From: Ruben Lopez <Ruben.Lopez@lincolnshire.gov.uk>
Sent: 12 May 2026 15:04
To: _planningadvice
Cc: Bryan, Jacob
Subject: RE: Consultation - H22-0353-26: MAGPIE COTTAGE

H22-0353-26: MAGPIE COTTAGE

The proposed development will comprise: *Self Build Replacement Dwelling*- including demolition of Magpie Cottage.

TITLE
EXISTING PLANS & ELEVATIONS

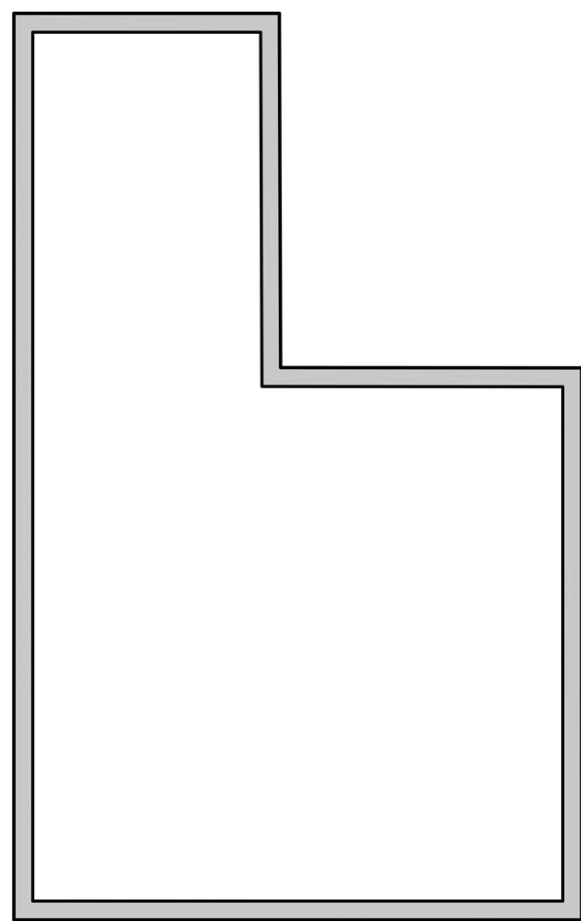
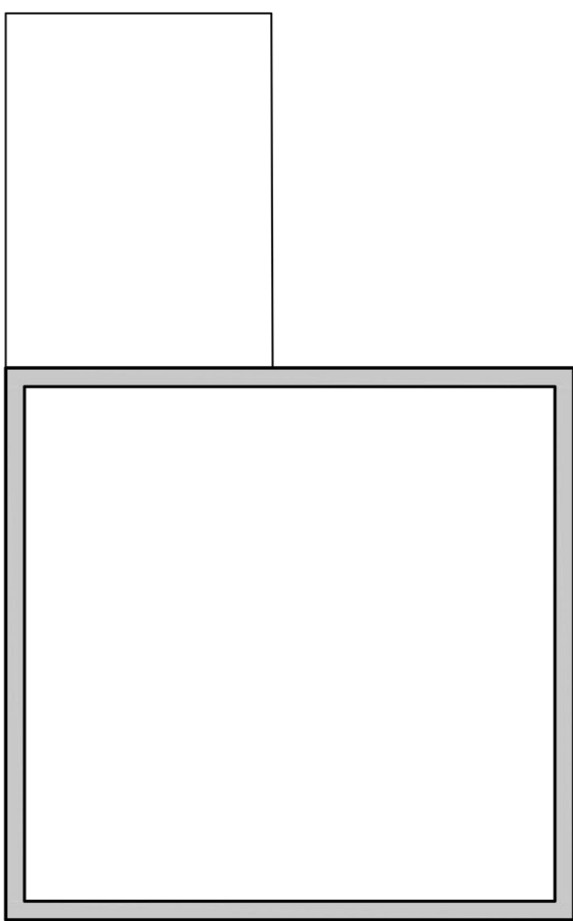
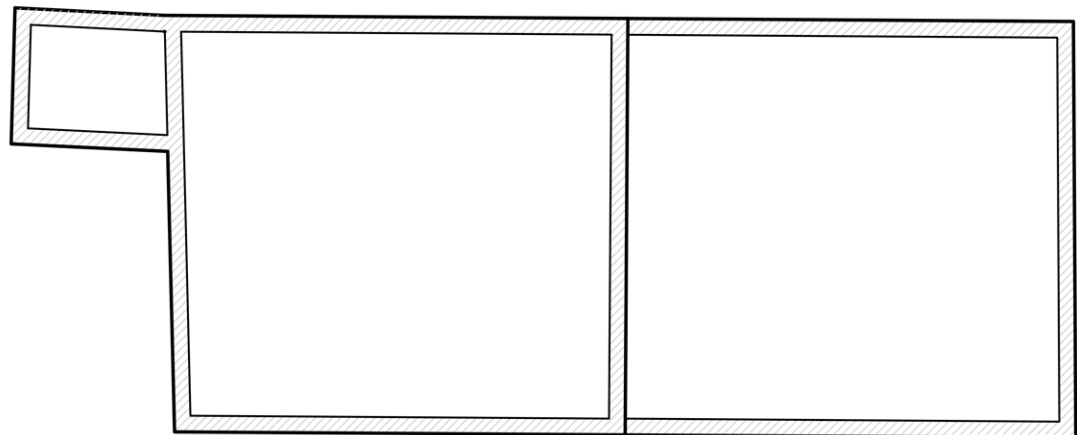
Magpie Cottage is considered to be a non-designated heritage asset of local significance on account of its historic agricultural character and evidential value as a surviving 19th-century farmstead. Its presence is confirmed by the Ordnance Survey Historic Map of 1892–1914, indicating that it forms part of the historic rural landscape of South Holland. Nineteenth- and early 20th-century farmsteads are recognised as an important component of the historic environment in both Historic England’s *Agricultural Buildings: Listing Selection Guide* (April 2011) and the *Greater Lincolnshire Farmsteads Project* (Historic England, 2015).

The demolition of this building would result in the erosion of the area's historic environment and sense of place, which directly conflicts with the National Planning Policy Framework's (NPPF) aim of preserving buildings of local interest.

The building is recorded on the Historic Environment Record (HER) under monument number MLI122951. As such, the scale of harm or loss must be carefully weighed in determining any application that directly or indirectly affects its significance (NPPF, paragraph 216 Dec 2024). The complete demolition of the farmhouse would constitute total loss, which should be avoided unless exceptional circumstances are demonstrated.

The NPPF emphasises the desirability of sustaining and enhancing the significance of heritage assets, including through their conservation and viable use (NPPF, paragraphs 203 and 210, December 2024). The submitted application has not adequately explored the potential for retaining and adapting the existing building for continued residential use, which would better align with sustainable development principles. This is particularly relevant given that the submitted information does not demonstrate that repair or adaptation would be unviable, and given the embodied carbon represented by the existing building fabric.

I recommend that the applicant submit the results of a Heritage Impact Assessment (HIA) informed by a Structural Report and a level 3 historic building recording of Magpie Cottage and its associated outbuilding in accordance with Historic England's document 'Understanding Historic Buildings: A Guide to Good Recording Practice. (2016). This will be in accordance with Historic England Advice Note 12: Statements of Heritage Significance: Analysing Significance in Heritage Assets. The structural report should specifically assess the nature, extent and significance of the alleged structural movement, the feasibility of repair, and whether demolition is genuinely justified rather than merely preferable on cost or design grounds.
